**EL PASO COUNTY PLANNING AND
 COMMUNITY DEVELOPMENT
 DEPARTMENT**

GRADING AND EROSION CONTROL PLAN CHECKLIST

Revised: July 2019

VTC-1. AGGREGATE VEHICLE TRACKING CONTROL

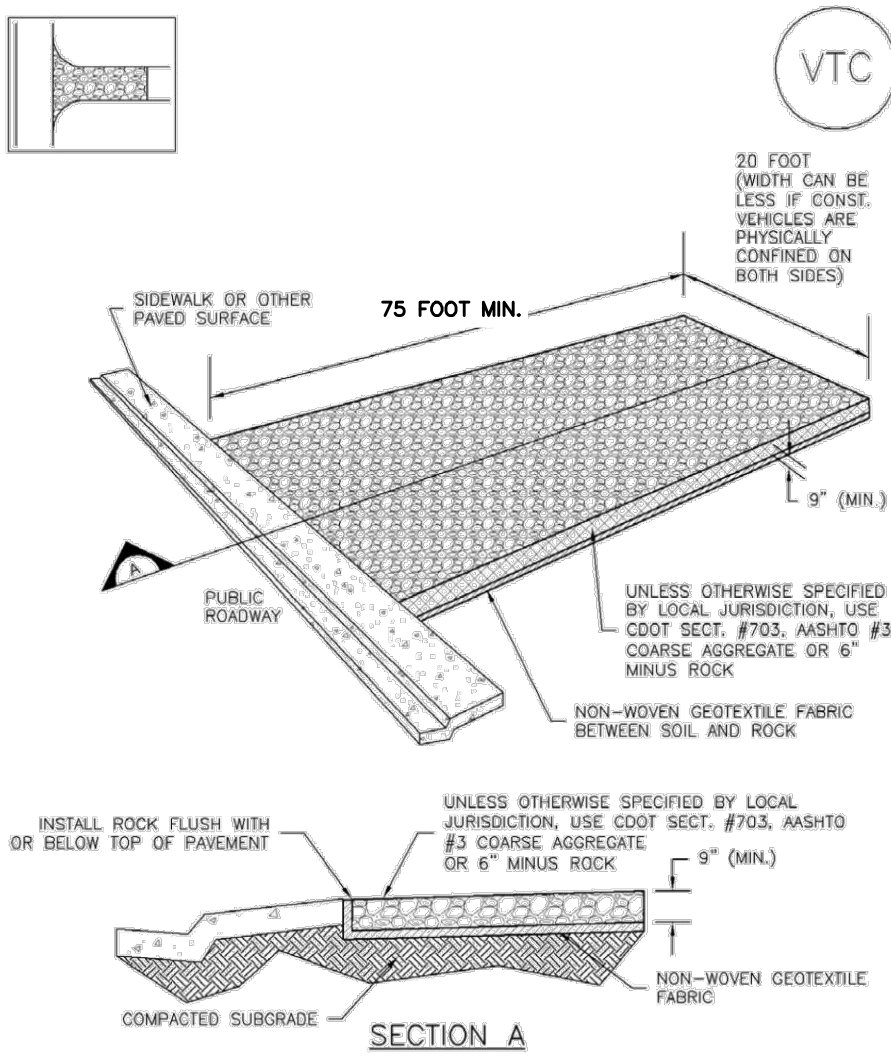
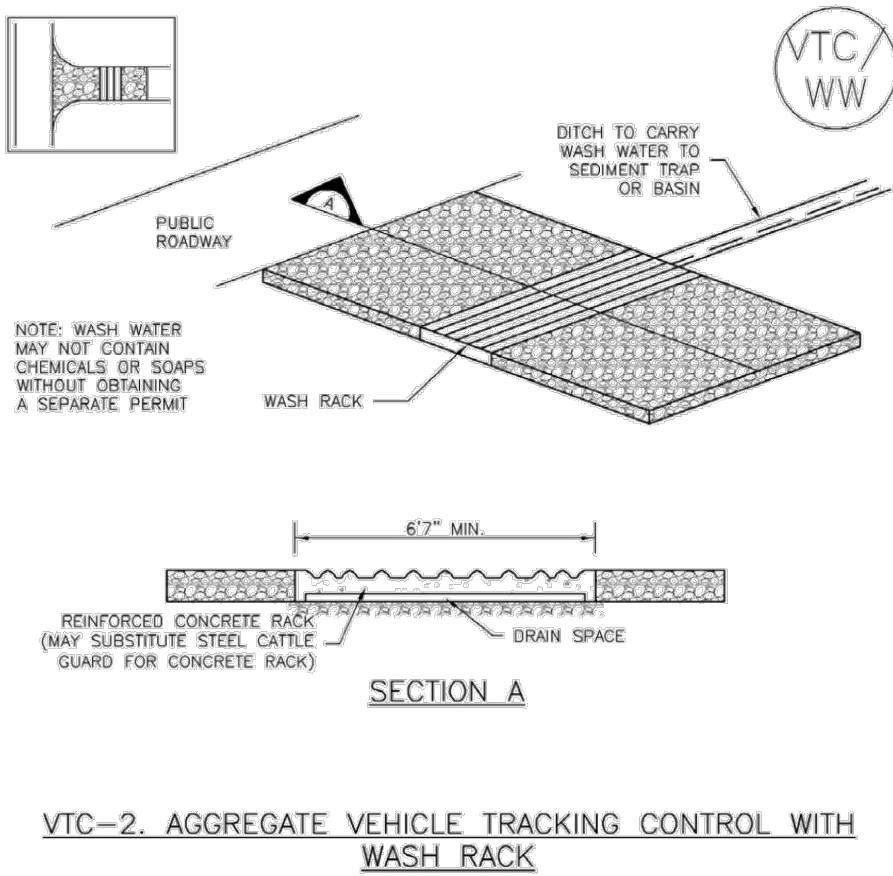
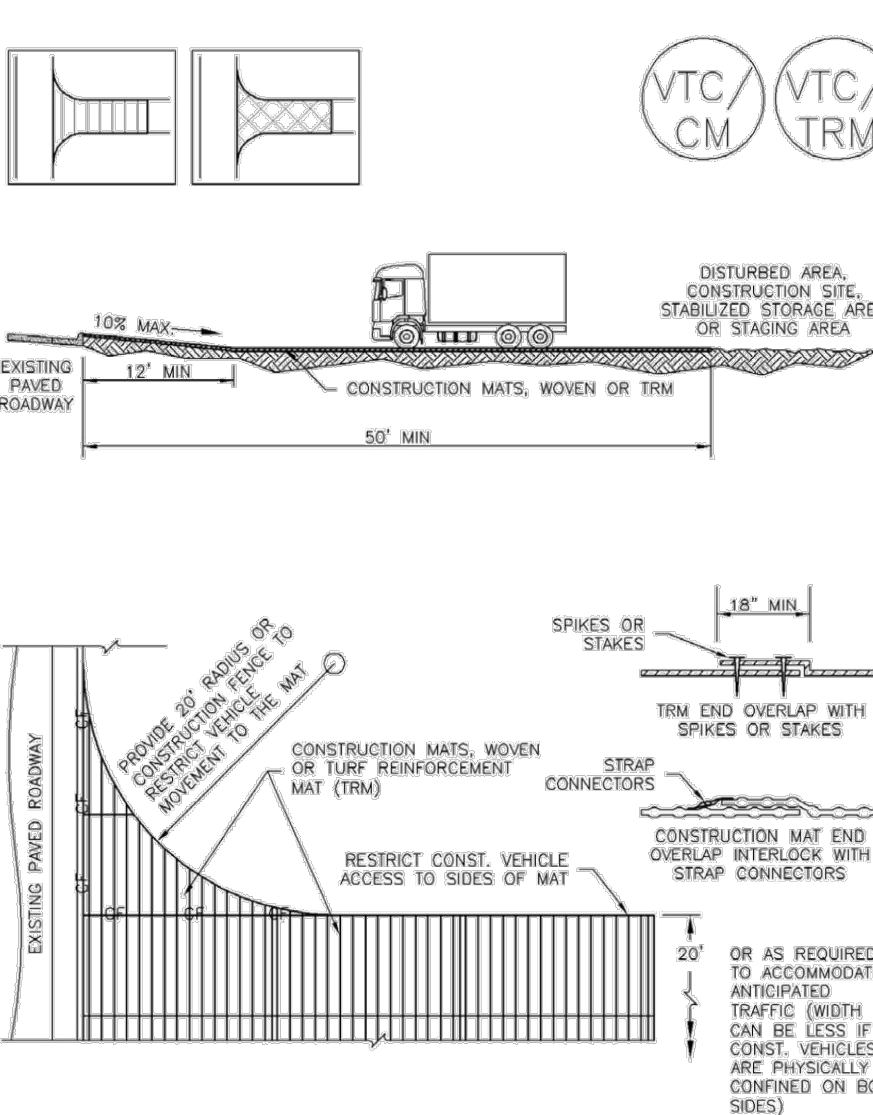
v	All proposed temporary construction control measures, structural and non-structural. Temporary construction control measures shall be identified by phase of implementation to include "initial," "interim," and "final" or shown on separate phased maps identifying each phase.	x	Y
w	Vehicle tracking provided at all construction entrances/exits. Construction fencing, barricades, and/or signage provided at access points not to be used for construction.	x	Y
x	Temporary sediment ponds provided for disturbed drainage areas greater than 1 acre.	n/a	N/A
y	Dewatering operations to include locations of diversion, pump and discharge(s) as anticipated at time of design.	n/a	N/A
z	All proposed temporary construction control measure details. Custom or other jurisdiction's details used must meet or exceed EPC standards. Revise min VTC length	x	N
